**DEVIATION REVIEW  
 AND DECISION FORM**

DEV18006 →

**FLYING HORSE NORTH**  
**(Cul-de-sac bulb grade)**

Specific Criteria from Which a Deviation is Sought: Section 2.3.8.A Fig. 2-31 Rural cul-de-sac bulb grade

FLYING HORSE NORTH FILING NO. 1			
STREET IMPROVEMENT PLAN			
GOLD RUN COURT			
(STA. 1+02.00-STA. 12+50.00)			
DESIGNED BY	PRA	SCALE	DATE 08-11-17
DRAWN BY	PRA	(H) 1" = 50'	SHEET 24 OF 58
CHECKED BY	(V) 1" = 5'	JOB NO.	1096.11

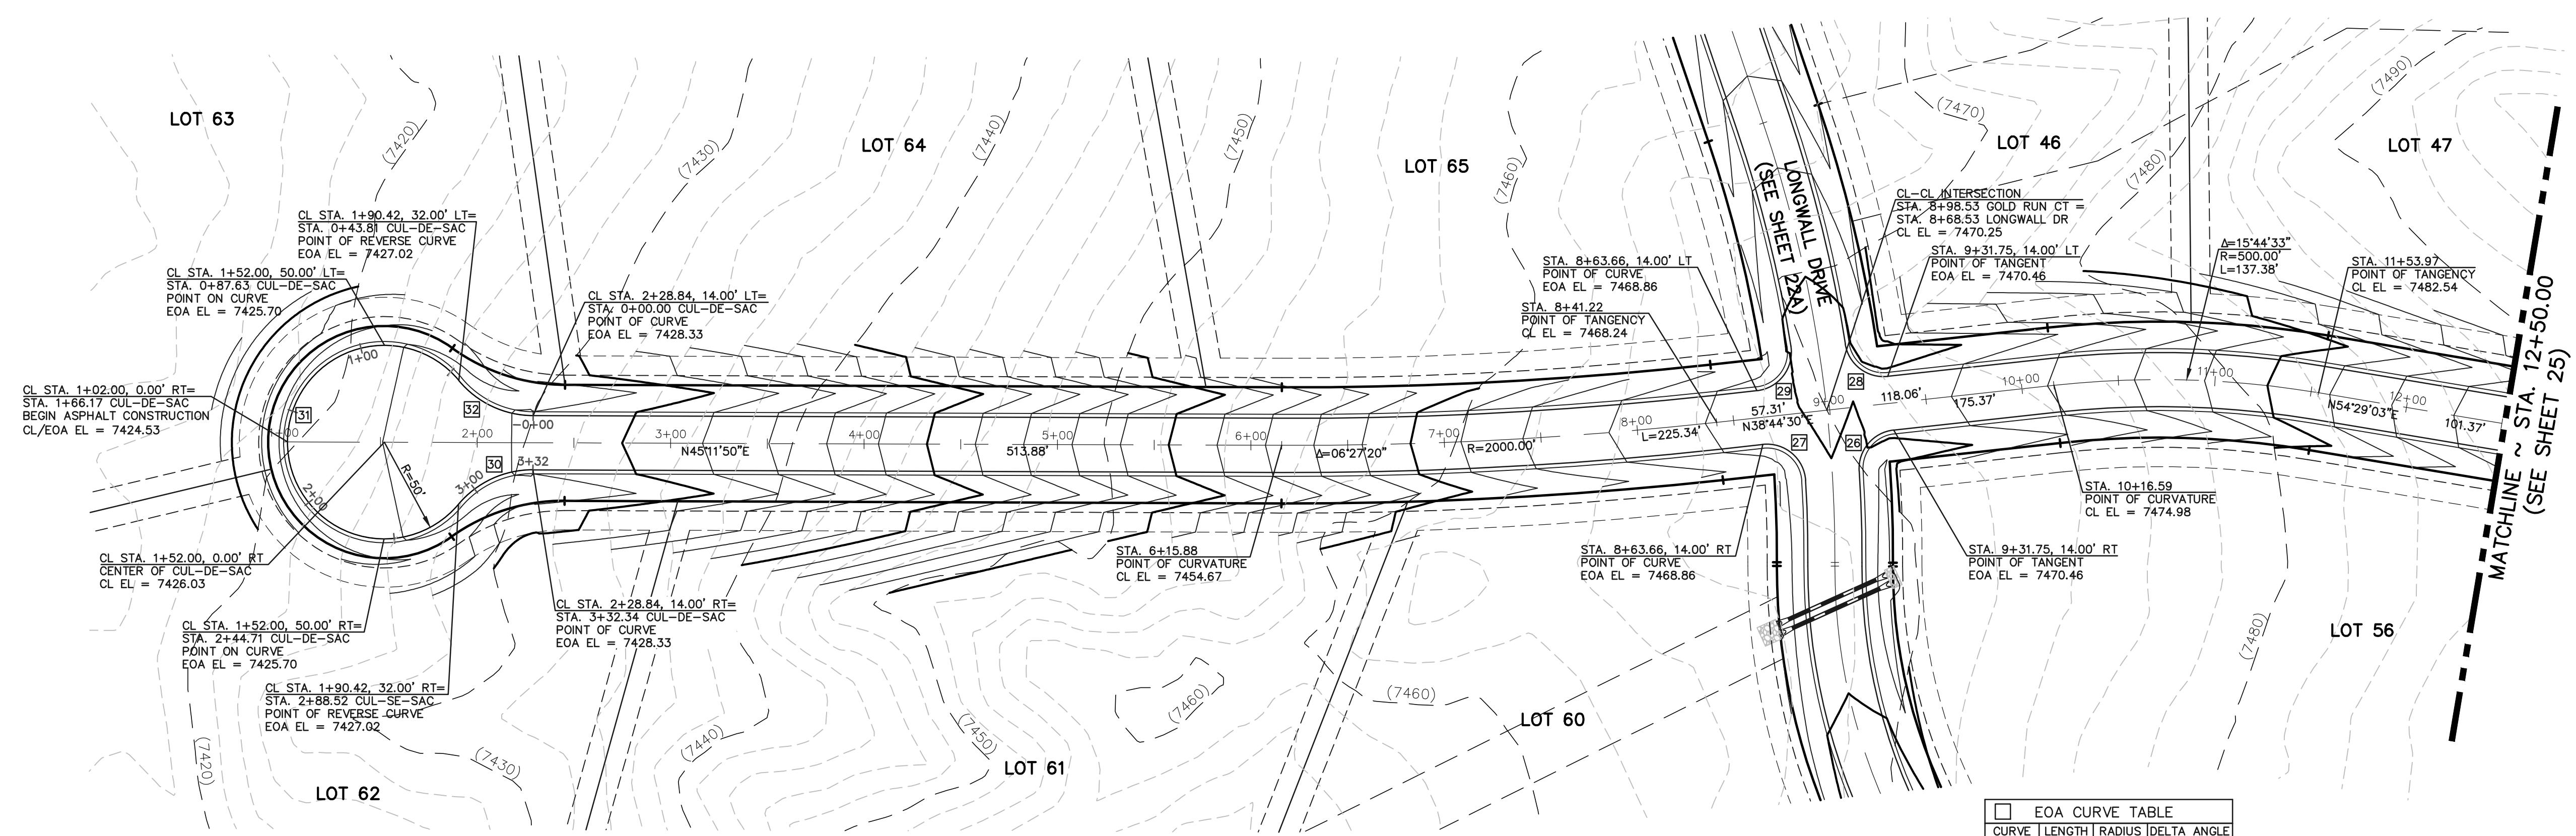
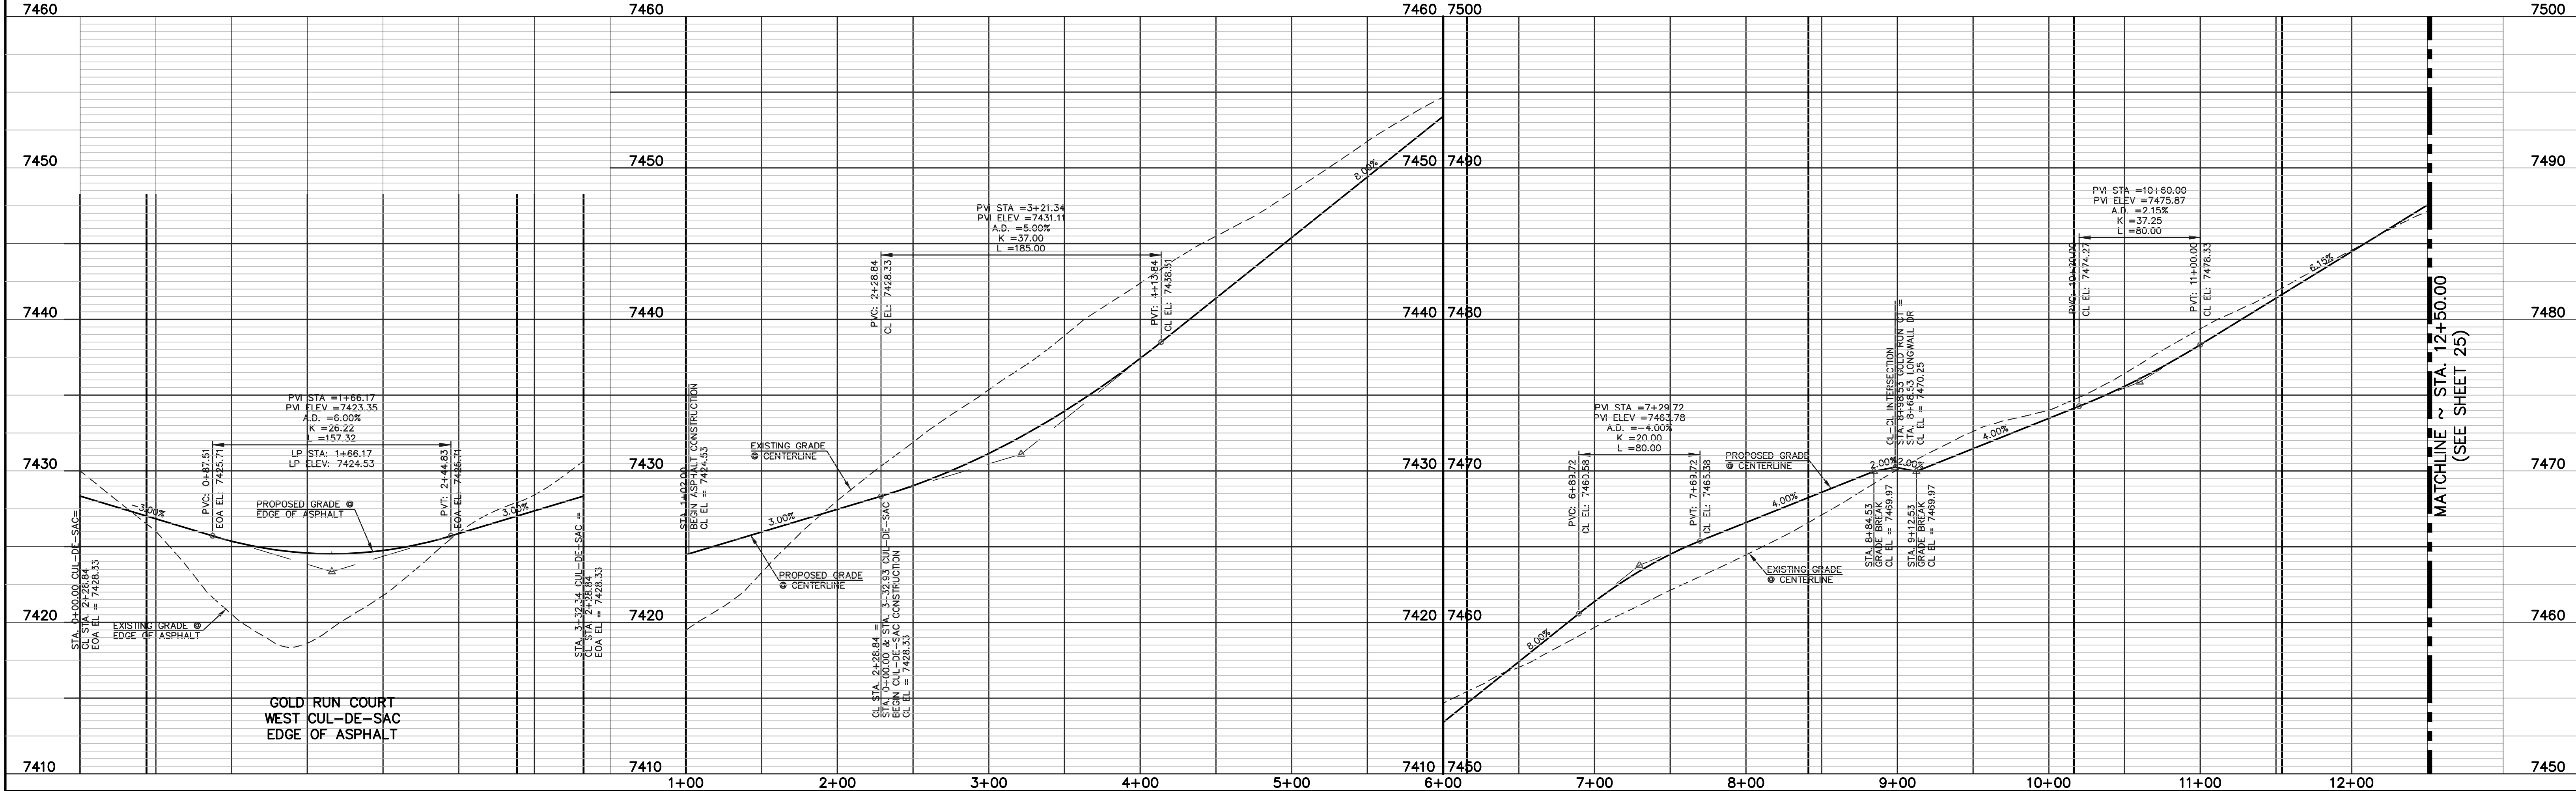
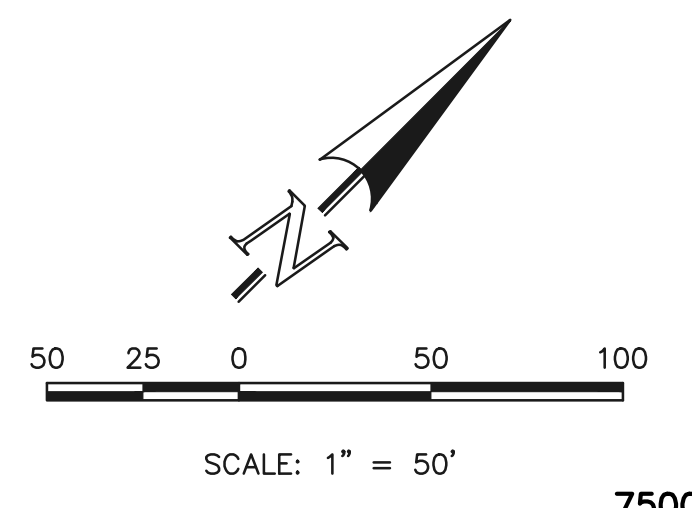
Safety and operation concern as vehicle navigate the cul-de-sac. Flatten the grade at the bulb. Staff will not support an 8% slope for the cul-de-sac but will support a 4% slope.

Contact the fire department to verify if they have specific criteria for the grade on the cul-de-sac. Provide a copy of their letter of support if they have no objections. Their criteria will govern if it is more restrictive.

Include as an attachment: Are the velocities of the roadside ditch around the bulb and as they exit the public ROW and drain across the private lots at erosive levels? Identify how it's mitigated if it is at erosive levels.
